WEST SUSSEX COUNTY COUNCIL CONSULTATION

TO:	Arun District Council FAO: Maria Tomalova
FROM:	WSCC - Highways Authority
DATE:	31 March 2021
LOCATION:	32 Sea Drive, Felpham, PO22 7NE
SUBJECT:	FP/51/21/PL Demolition & erection of 1 No. dwelling with associated works. This site is in CIL Zone 4 & is CIL Liable as new dwelling.
DATE OF SITE VISIT:	N/A
RECOMMENDATION:	Advice
S106 CONTRIBUTION TOTAL:	N/A

Title Ground Floor Plan

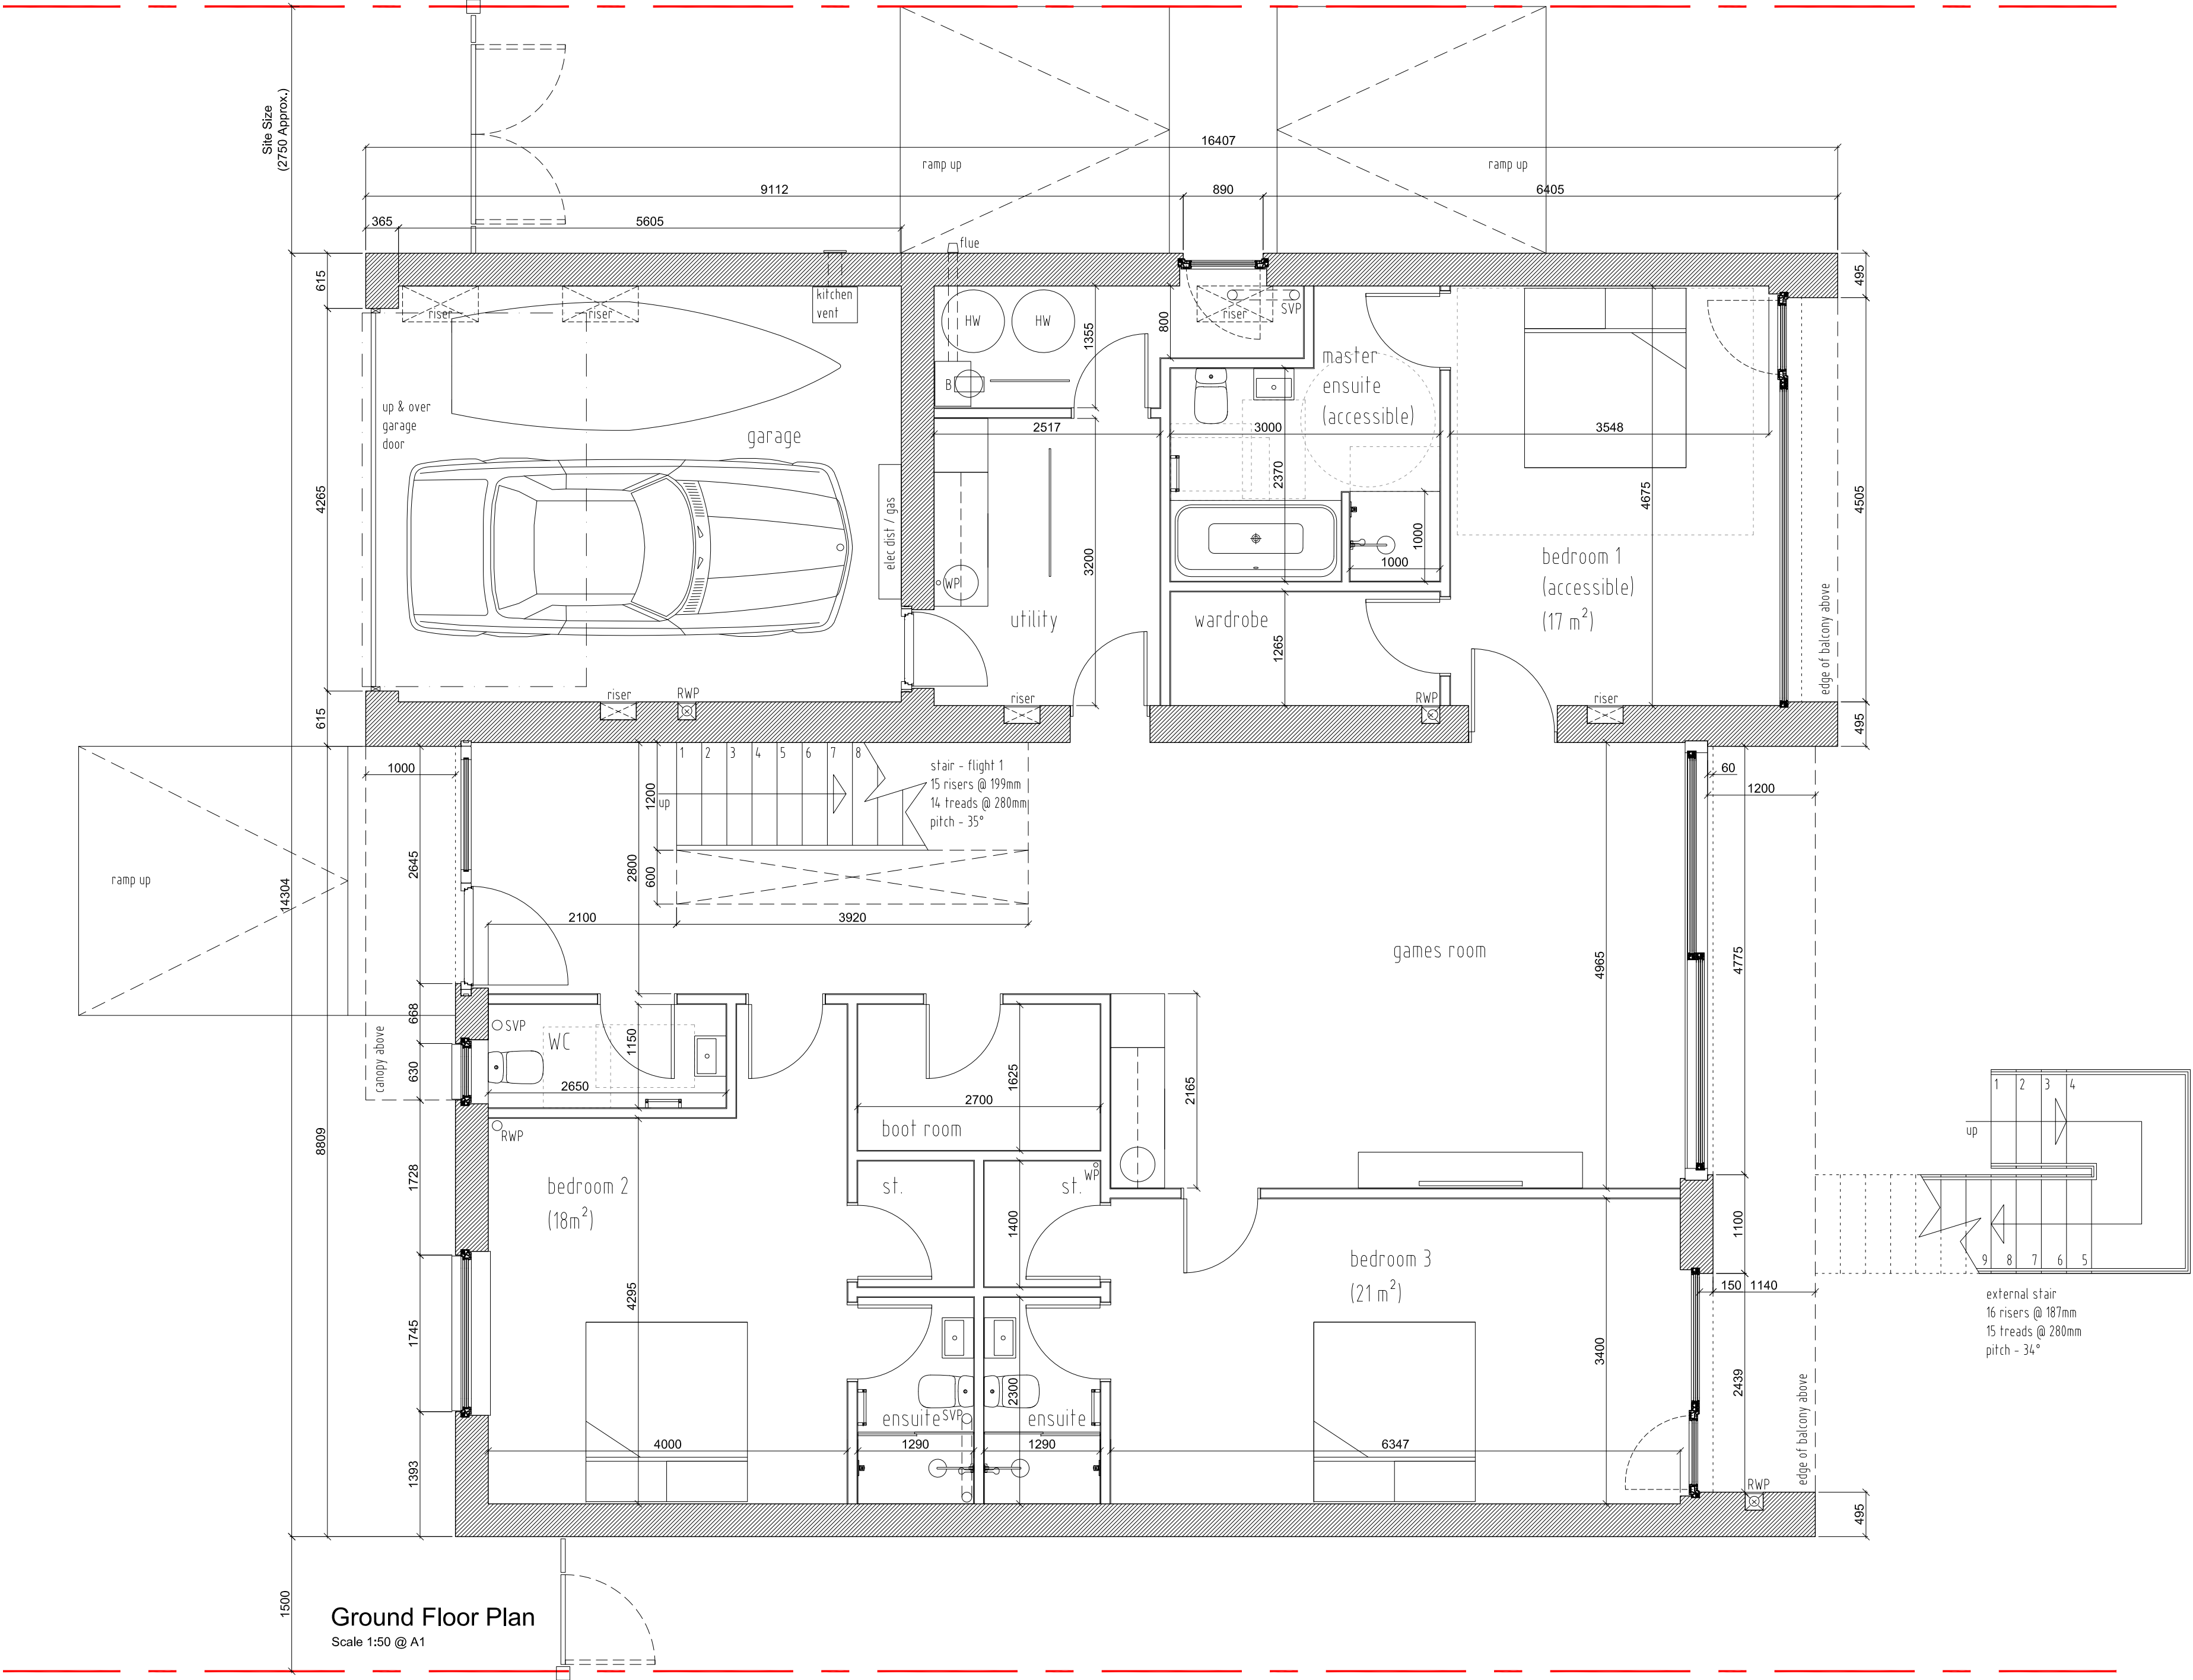
The LHA does note that the proposed garage does not meet the minimum internal specifications for single-car garages of 3m x 6m as set out in Manual for Streets (MfS). Therefore, the LHA cannot consider the garage for vehicular parking provision, as it may be too small for modern vehicles to fit inside. The LHA advises the applicant to enlarge the proposed garage to meet MfS specifications, so that it can be considered for vehicular and cycle parking provision. Notwithstanding this, the LHA is satisfied that sufficient parking provision is available on-site.

Regarding cycles, the applicant has not demonstrated cycle parking. Cycling is a viable option in the area and the LHA would like to see secure and covered cycle parking being implemented, to promote the use of sustainable transport methods. The LHA notes that if the garage is enlarged to MfS specifications, the LHA can consider it for cycle parking provision.

Site Plan as Proposed
Scale 1:200 @ A2

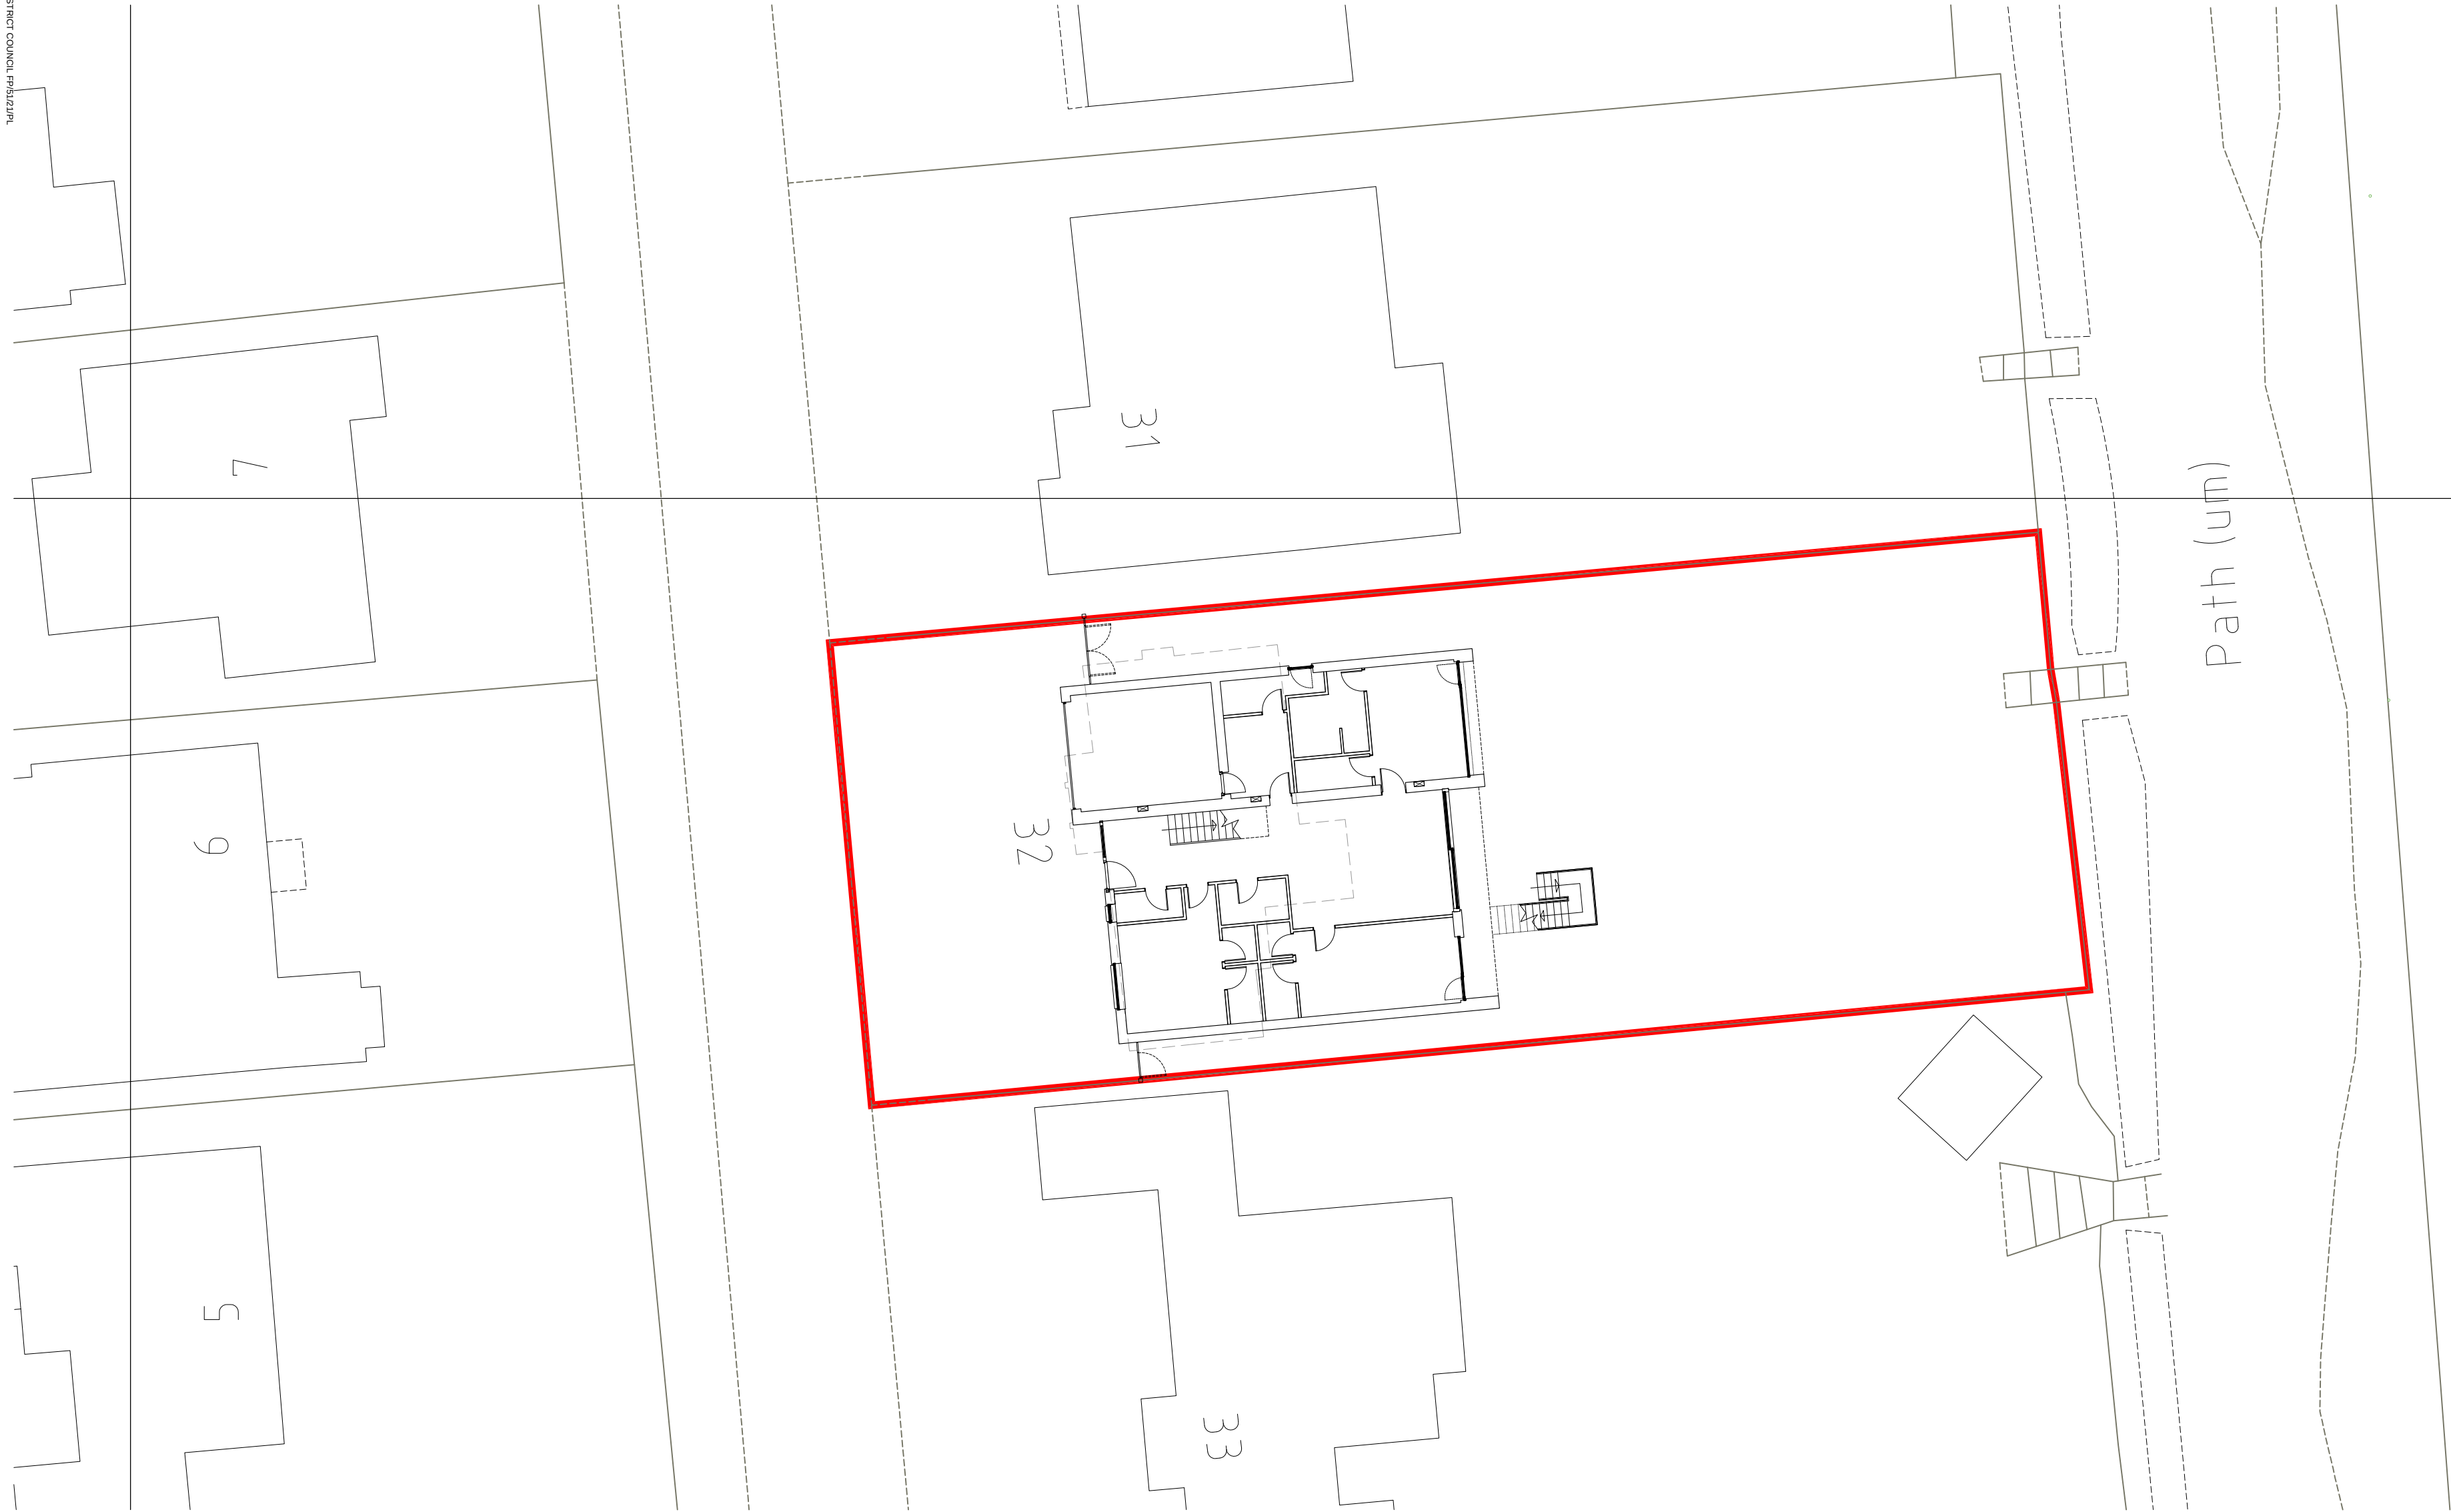
The applicant proposes a single-car garage and driveway for vehicular parking provision. Under Arun Parking Standards, the LHA would expect a dwelling of this size to provide at least three car parking spaces. From inspection of the plans, there appears to be sufficient space for this parking demand to be accommodated. On-site turning appears achievable, allowing vehicles to exit the site in a forward gear.
